ENG-CDR21014-R2-CDs.pdf Markup Summary

DROP STRUCTURE  
DETAILS (#4, #5, #6, #7, #8,  
#9, #10)

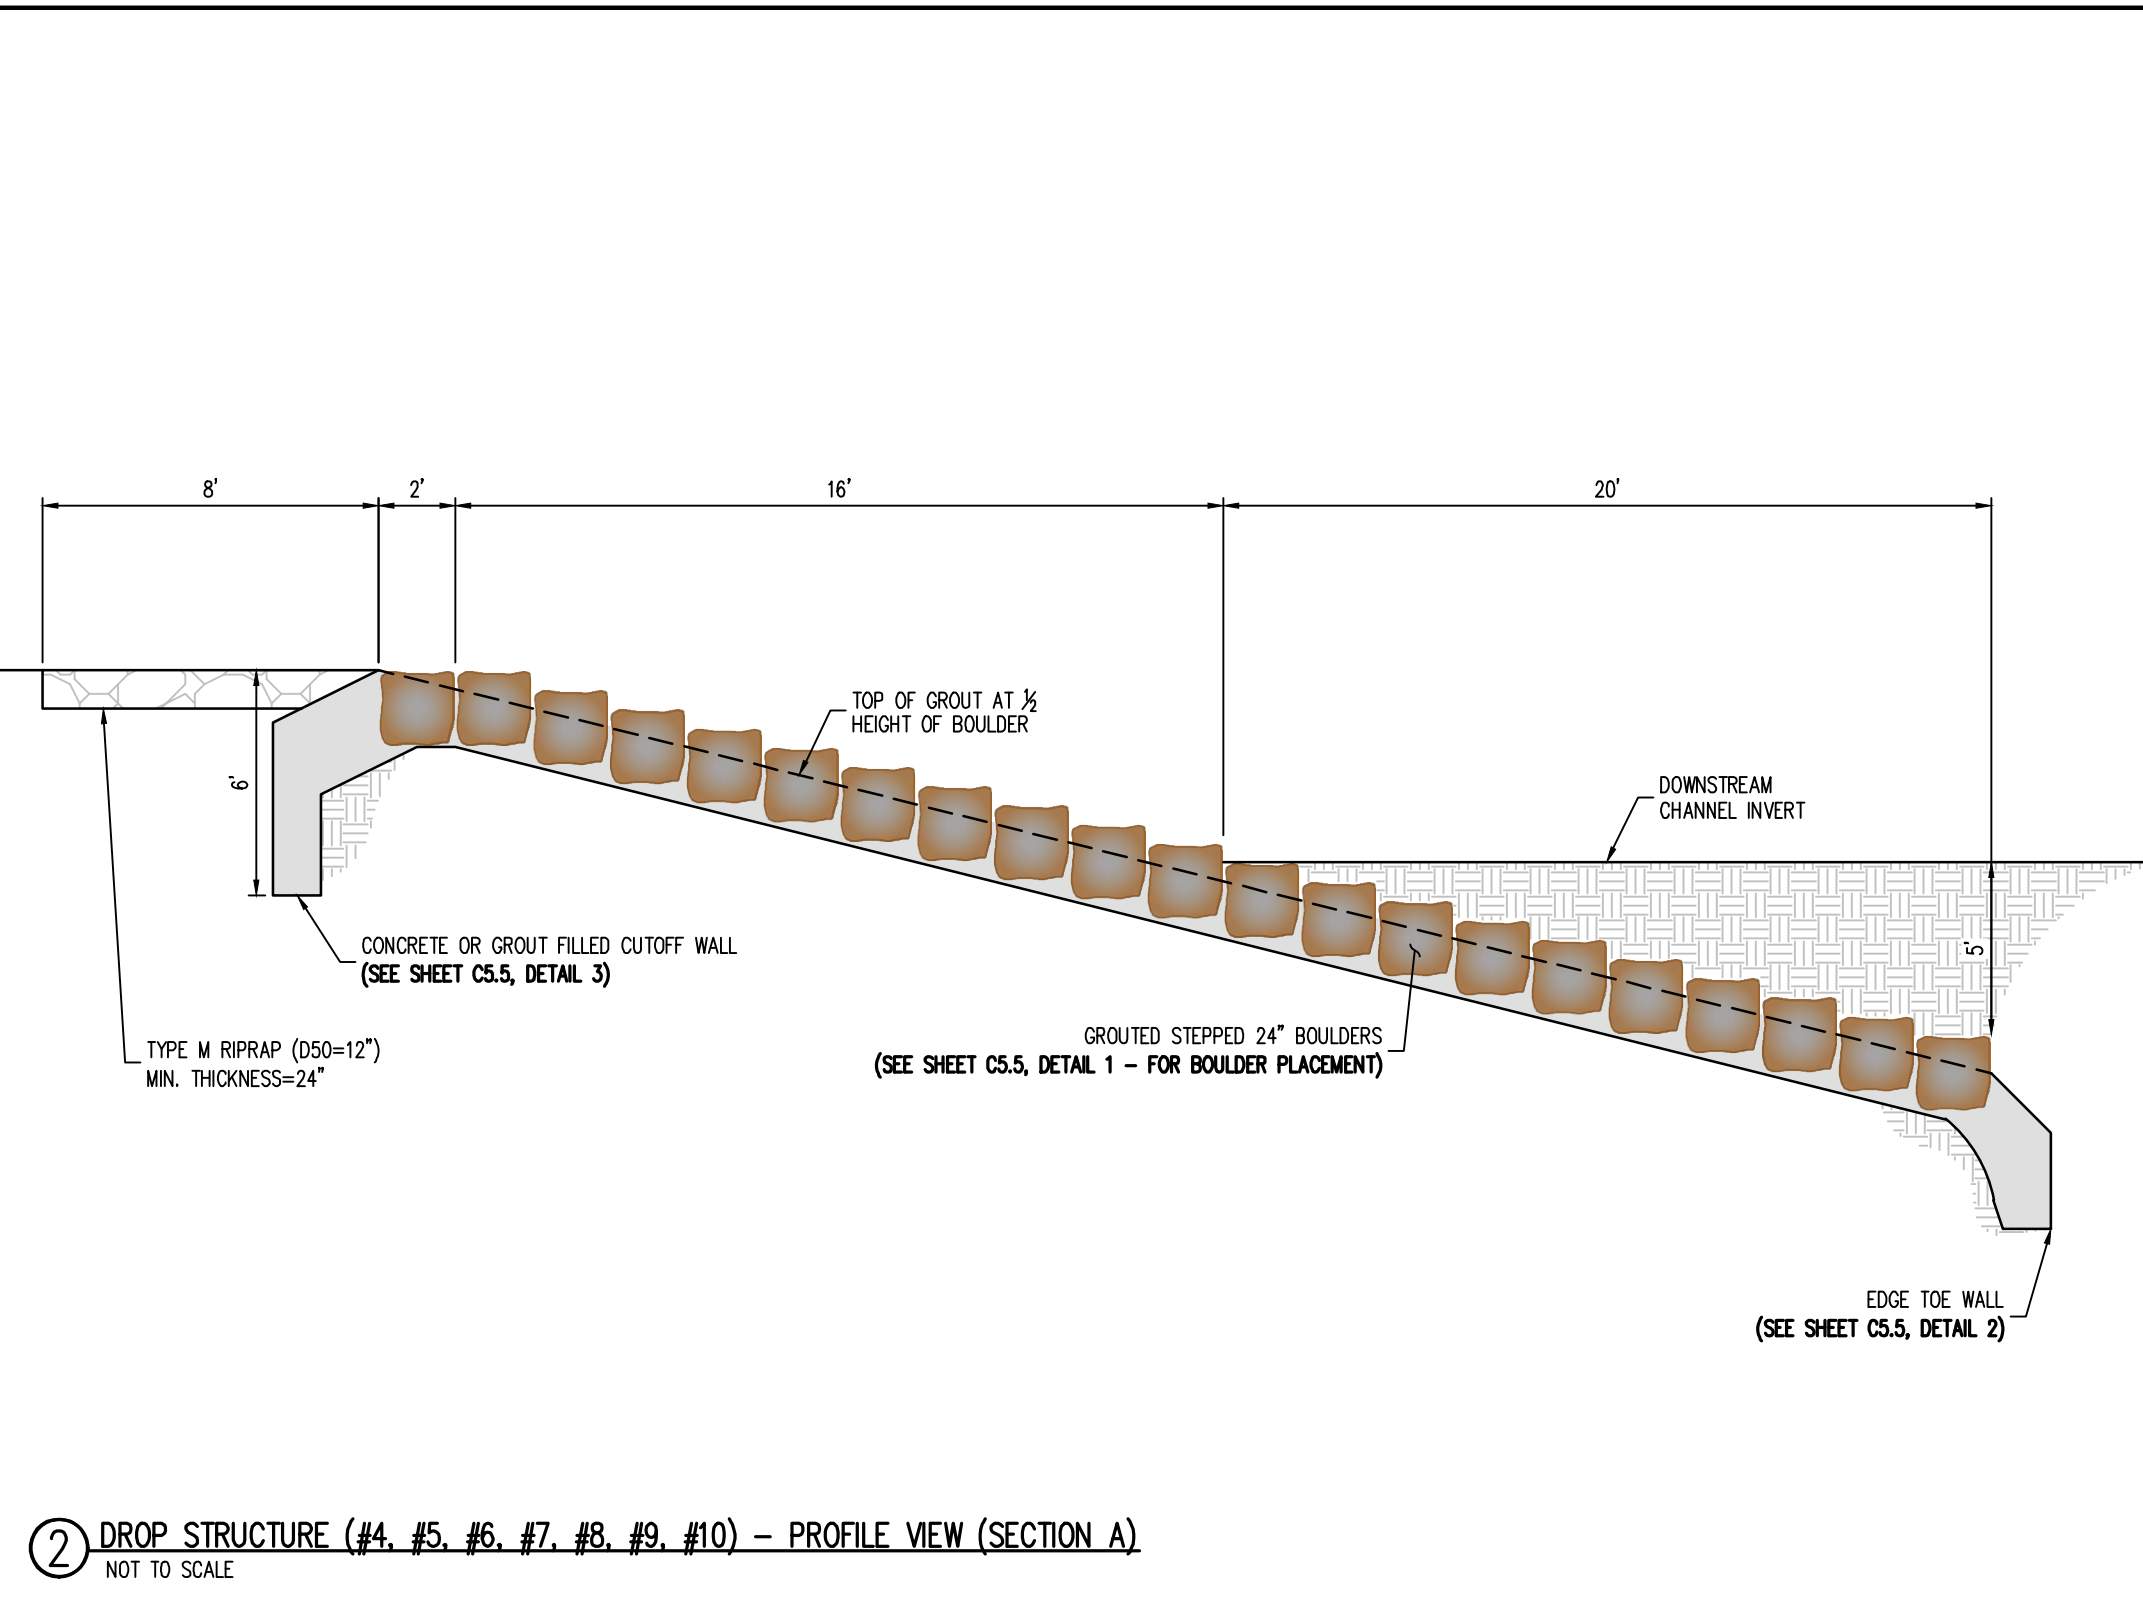
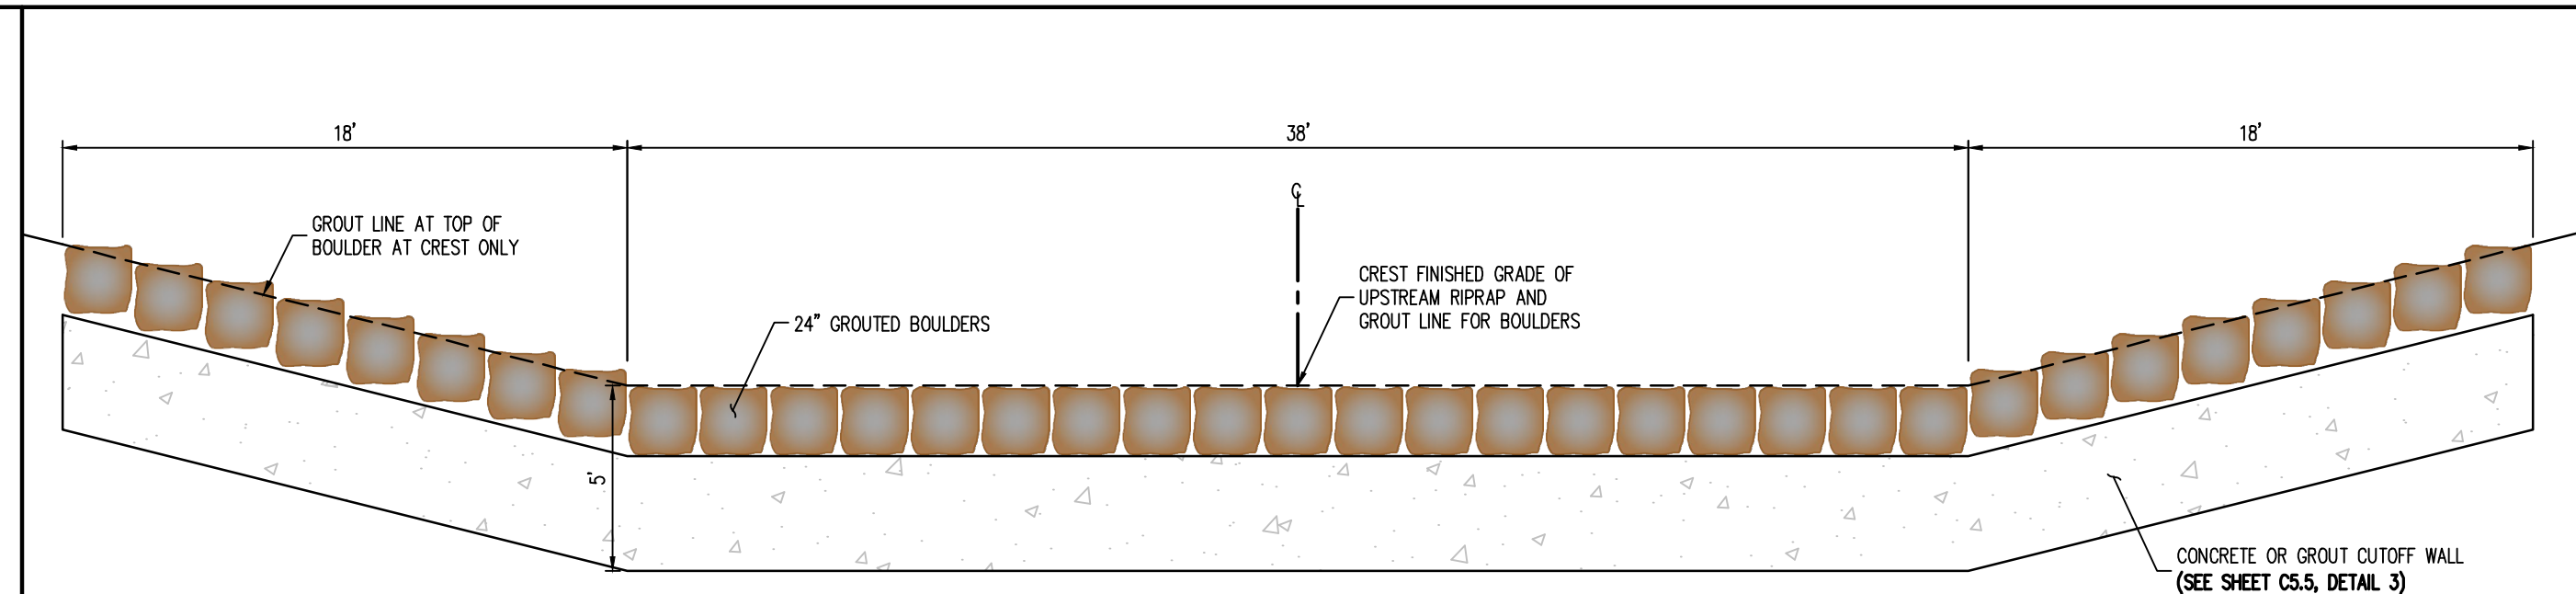
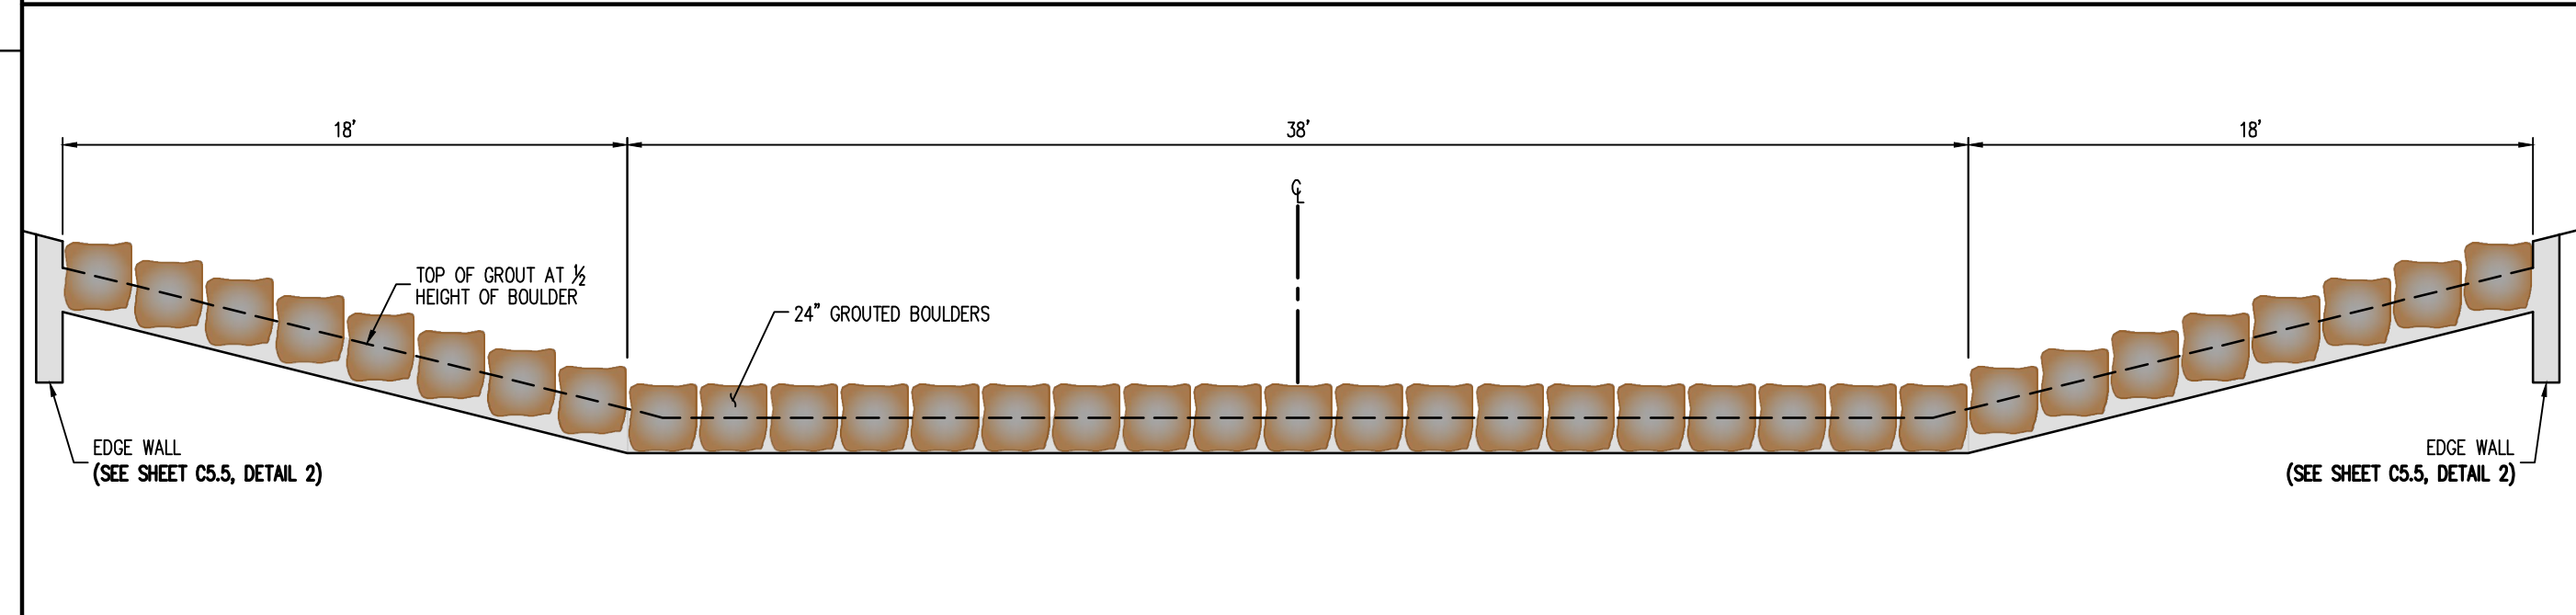
3?

Verify depth compared to profile sheet.
